The Secretary
NSW Planning, Industry & Environment

4 December 2019

I refer to the Department's letter of 5 November 2019 regarding State Significant Development SSD-8375 at 57-69 Tattersall Road, Kings Park (Lot 100 DP 792731) for 'Pick n Payless Metal Recovery and Recycling Facility including processing and recycling of scrap metal (up to 130,000 tonnes per year), motor vehicles, heavy and light gauge metals and changes to the site layout'. Submissions need to be made to the Department by 4 December 2019.

- BUILDING A - ADMINISTRATION
- BUILDING B - PROCESSING
- BUILDING C - ELV FACILITIES / VEHICLE PARTS STORAGE
- BUILDING D - ELV FACILITIES / VEHICLE PARTS STORAGE
- BUILDING E - YARD OFFICE AND PUBLIC ACCESS FOR PICK N PAYLESS
- BUILDING F - INDUSTRIAL SHED
- BUILDING G - INDUSTRIAL SHED

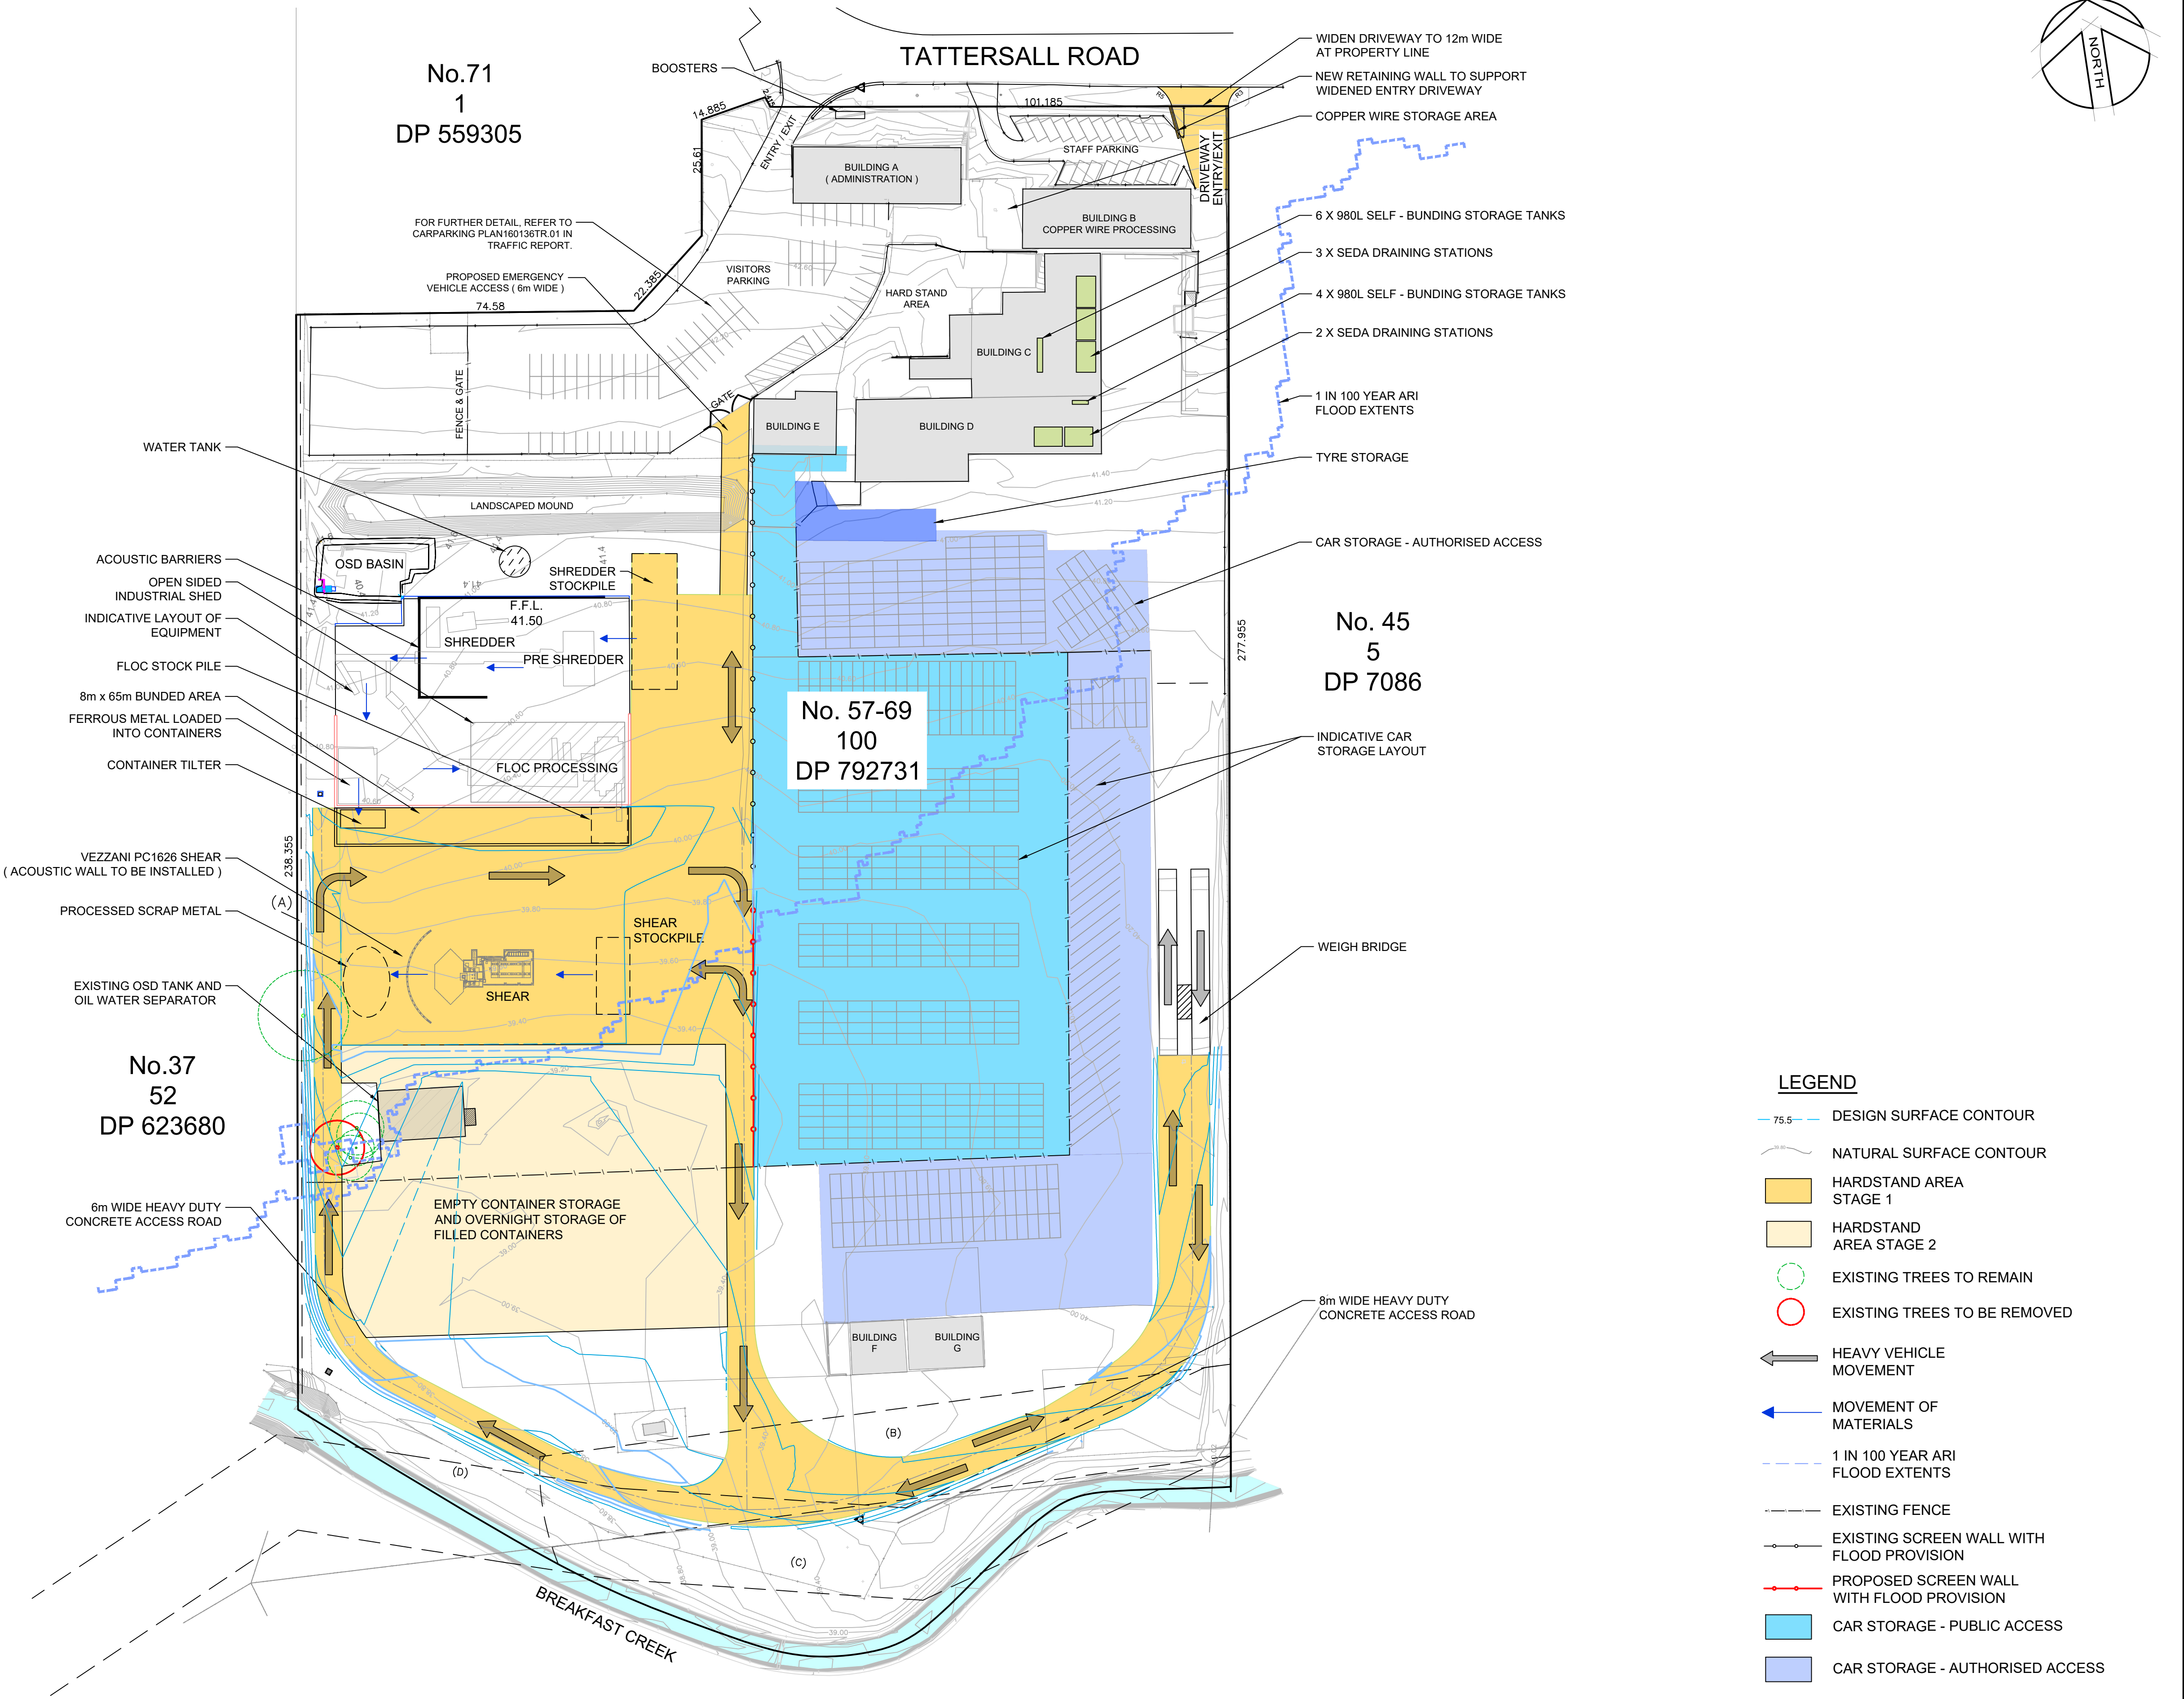
Endeavour Energy has noted that as shown in the following extract of the Development Plan the 'Copper Wire Storage Area' is in proximity of padmount substations (not shown on the plan).

In regard to the easement for overhead power lines, the Development Plan shows the access road in the easement.

Accordingly as mentioned above the applicant must contact Endeavour Energy's Easement Officer to assess all the proposed activities with the easements. Please note however that the foregoing does not imply or indicate the granting of permission to any or all of the proposed activities within the easements.
